ARCHITECTURAL DESIGN REPORT - ADDENDUM 01

Centre of Excellence in Agricultural Education

APPLICATION NO. SSD-1500146

1 BLOCK D - NORTH ELEVATION 1  
1 : 100

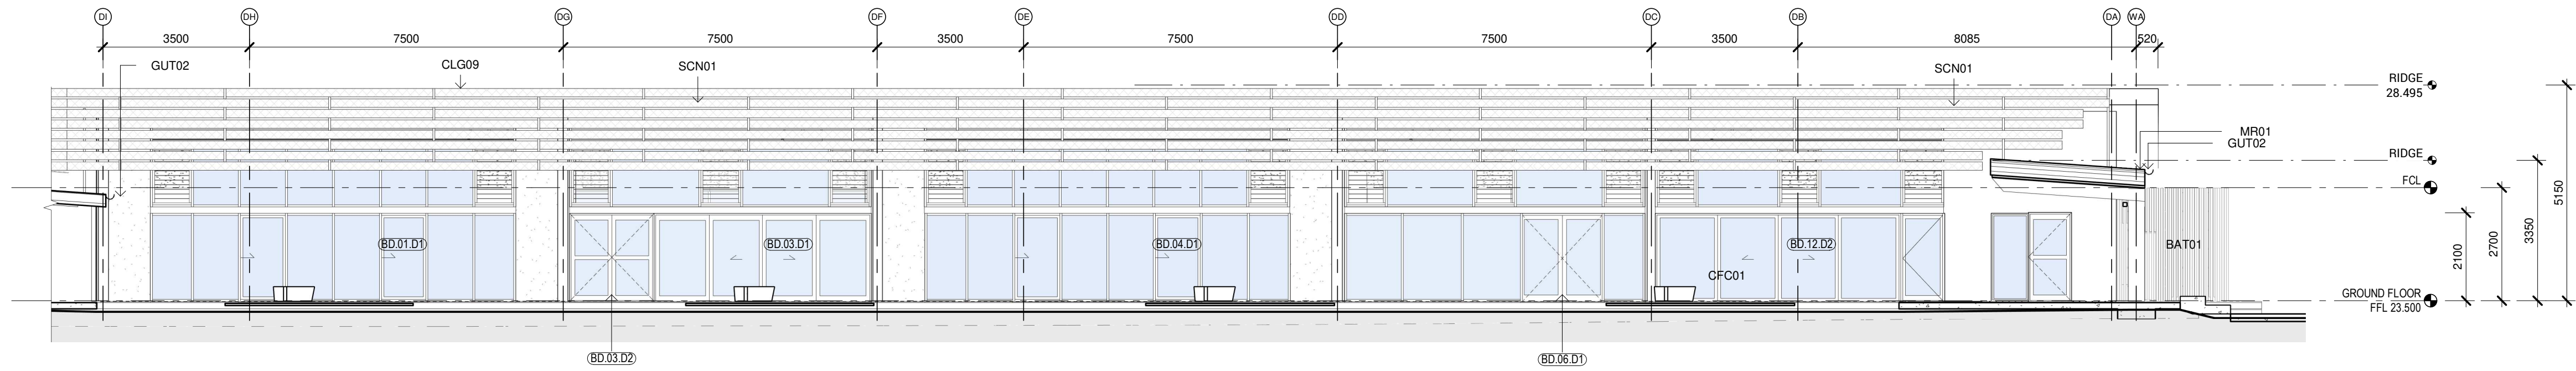
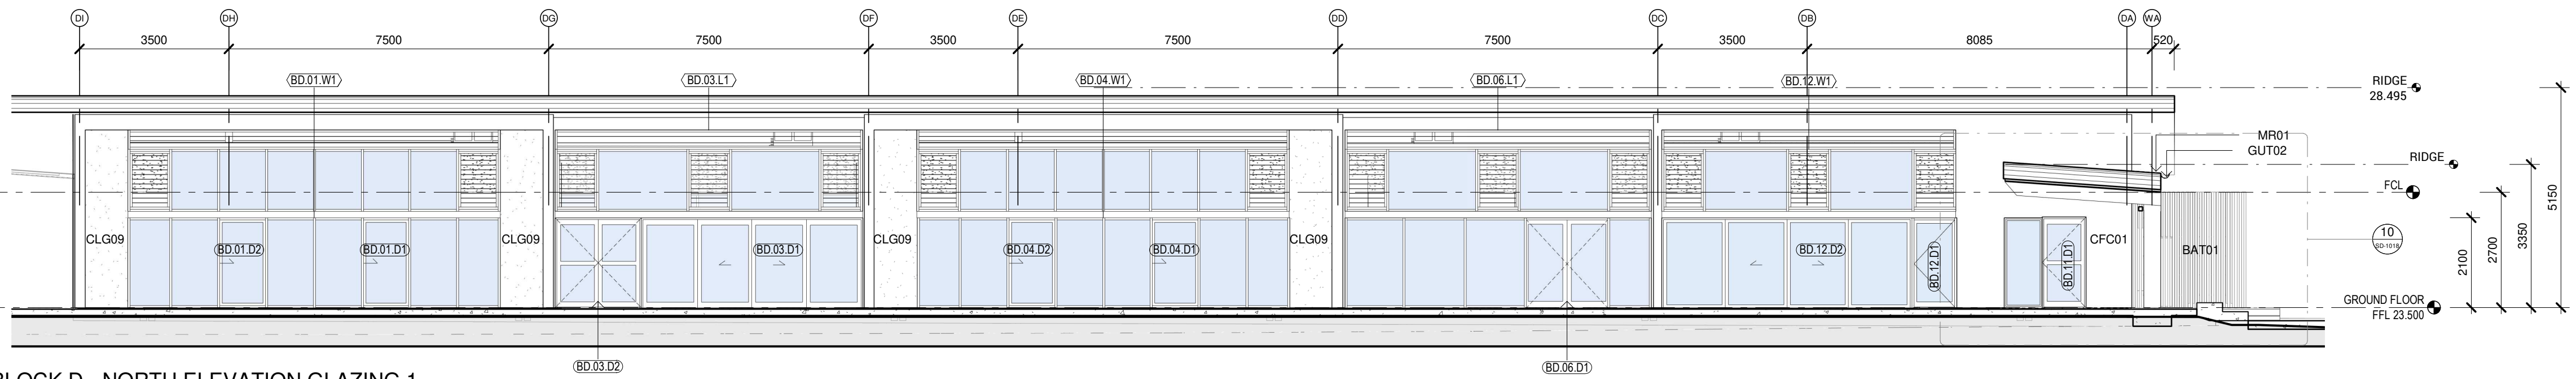
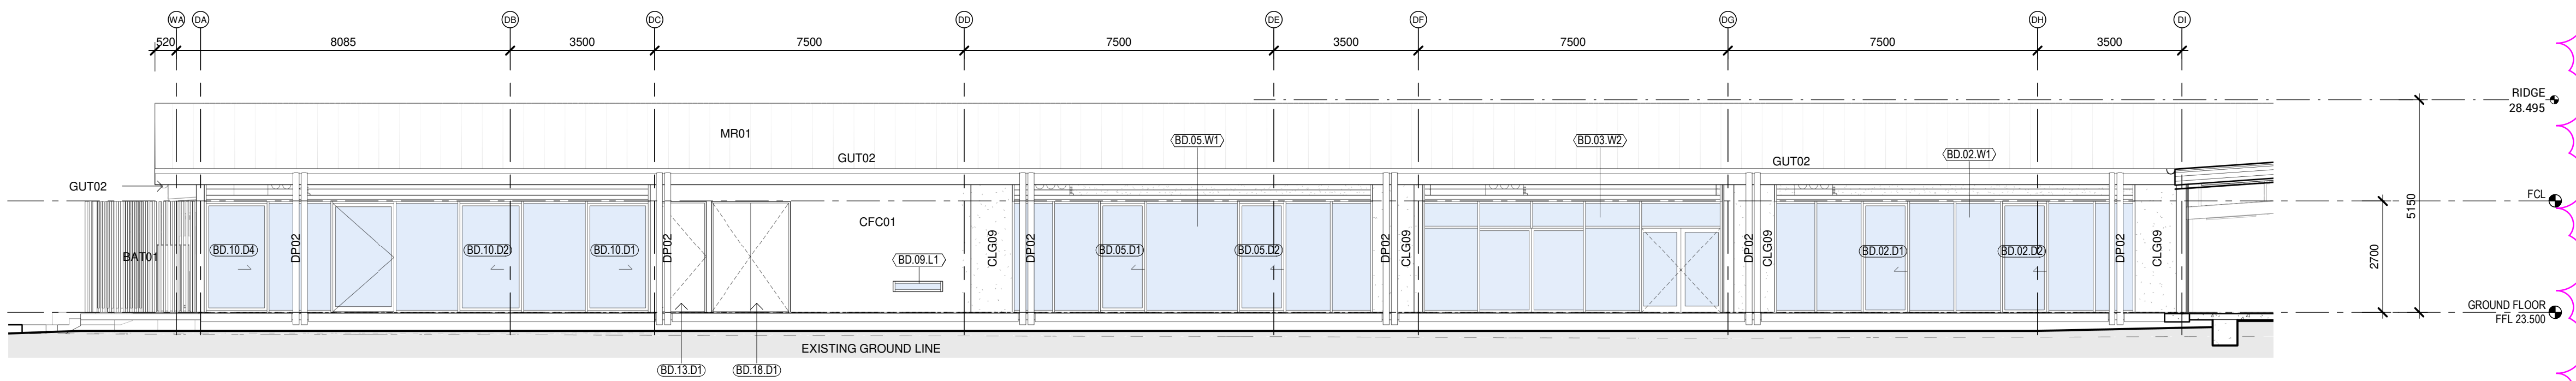
The three learning blocks, Building B, C and D, have received 15% reduction of the glazed area. This improves the overall structural design by providing additional structural support zones along the building facades. The following highlighted area of the building elevations illustrate the proportion of glazed façade that has been replaced with metal cladding with batt insulation.

1. Additional recessed façade alters the south elevation of building C and south façade of building D
2. The functionality of the science area in building D will significantly improve by flipping the Botany/ Zoology with the neighbouring Practical Activity Area. This provides the opportunity for better daylight harvesting & ventilation into the Botany and Zoology.

1 BLOCK E - NORTH ELEVATION 1  
1 : 100

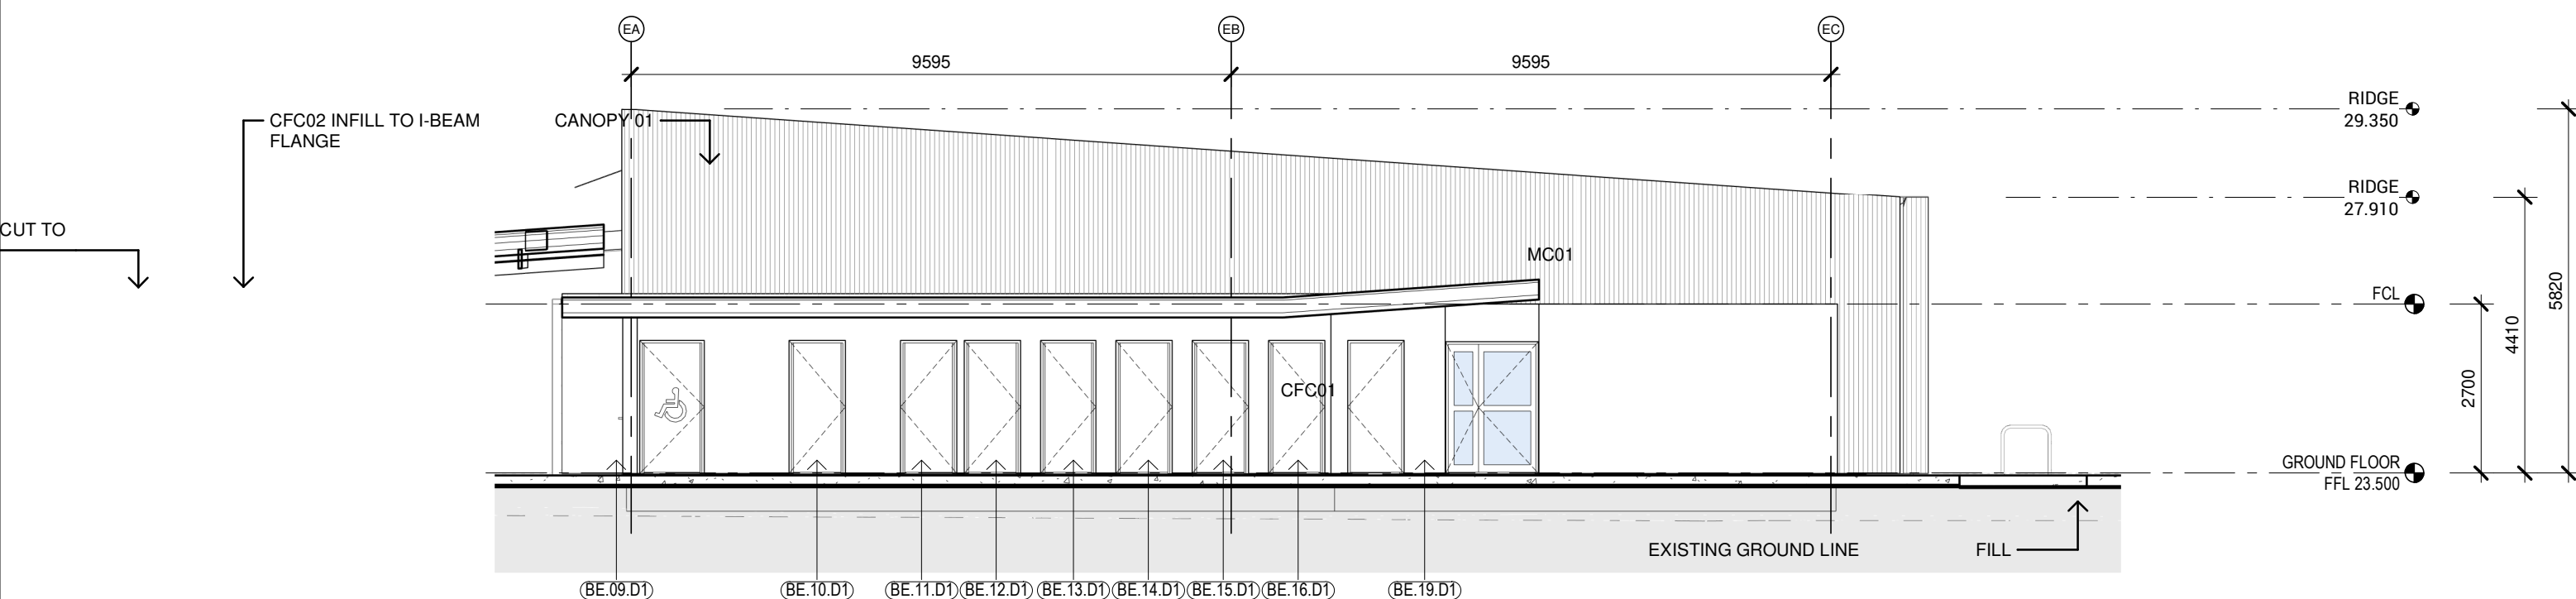
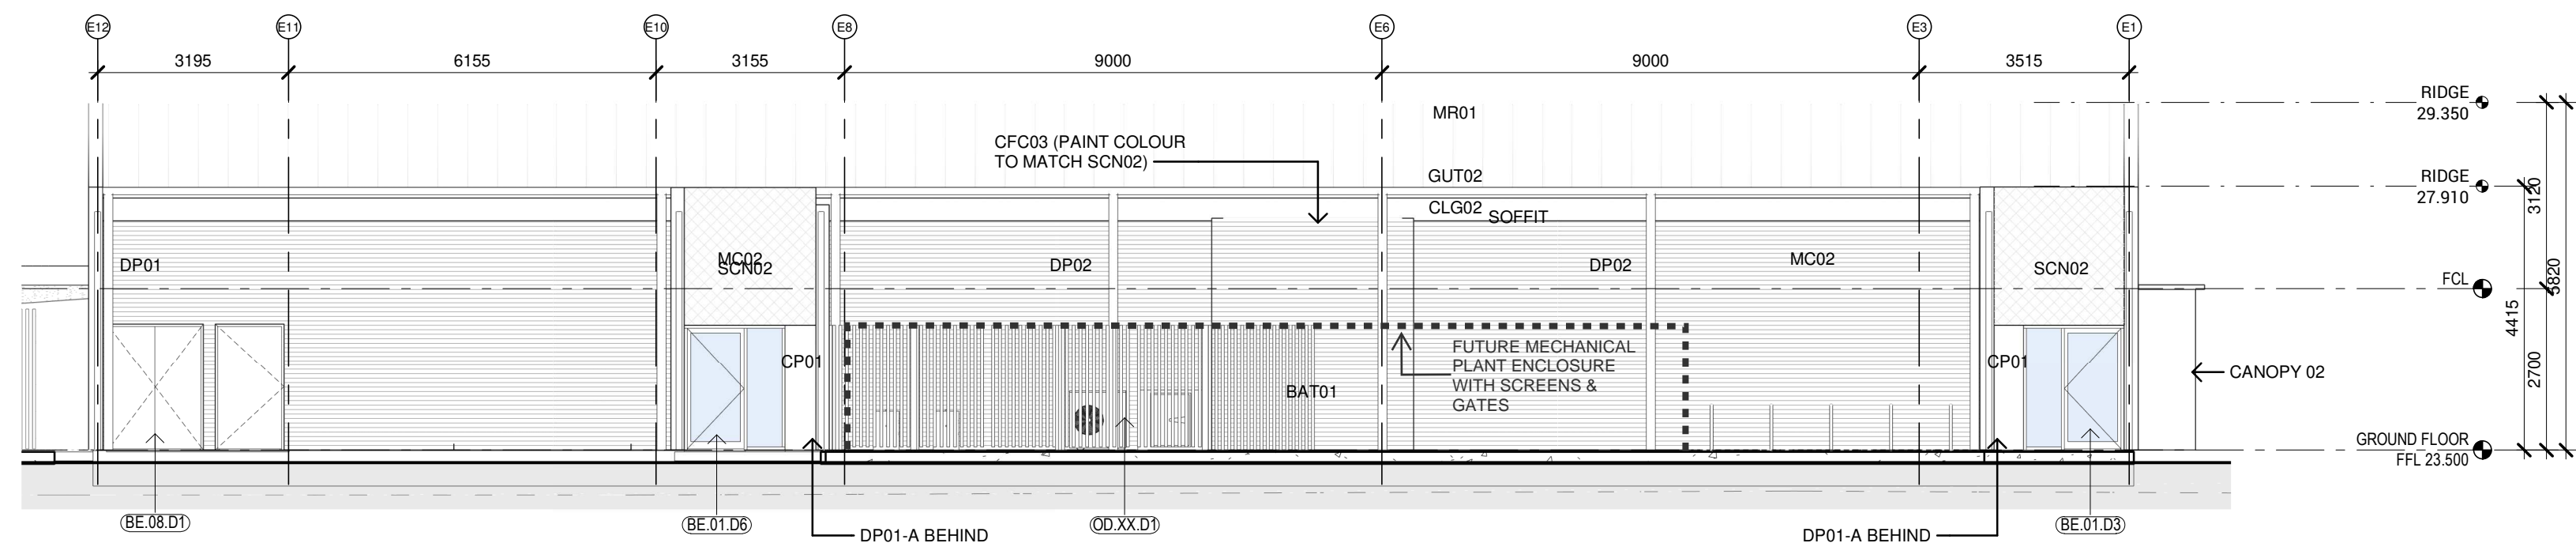
The following plan highlights two design changes which have resulted in the minor adjustment to the North & South Elevation of the building.

1. Design change 1 – Remove external protrusion of the recessed retractable doors as highlighted in light blue on the following drawing.
2. Design change 2 – Create an additional egress at mid-point of the southern portion of the Accommodation Block as highlighted in red lines & hatch on the following drawing.

5 BLOCK H - NORTH ELEVATION 1  
1 : 100

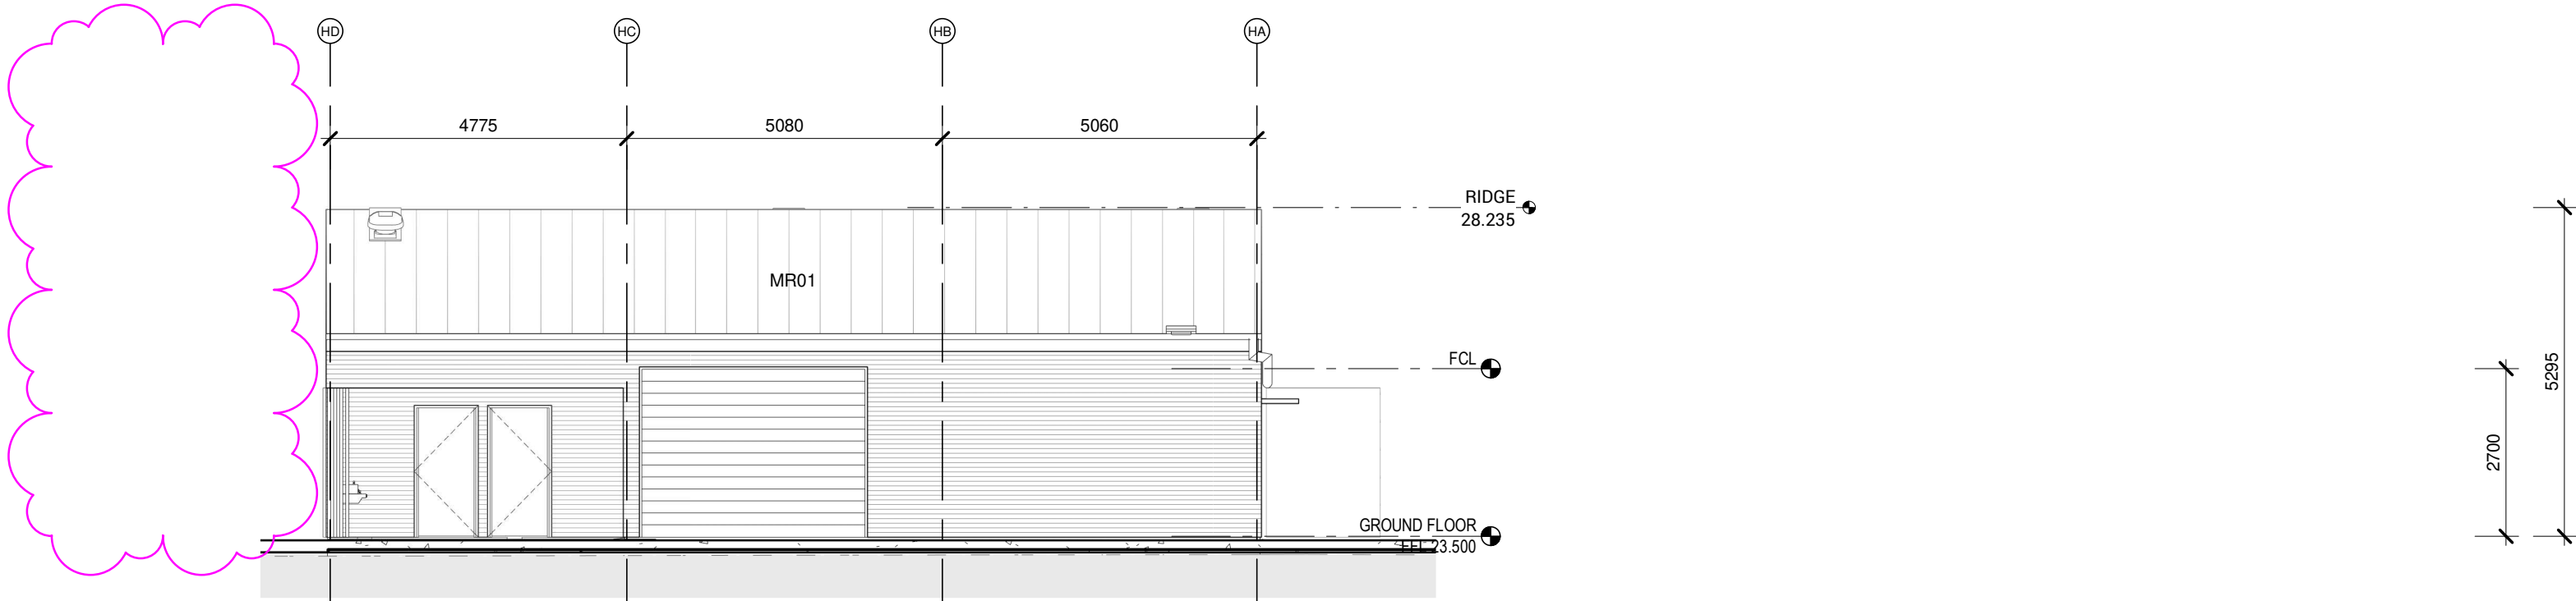
Building H is being flipped in East West direction to improve the connection and access from the main campus to the Covered Learning Area. Additionally, a dedicated staff WC & shower have been added to building H for use by the Farm Manager.
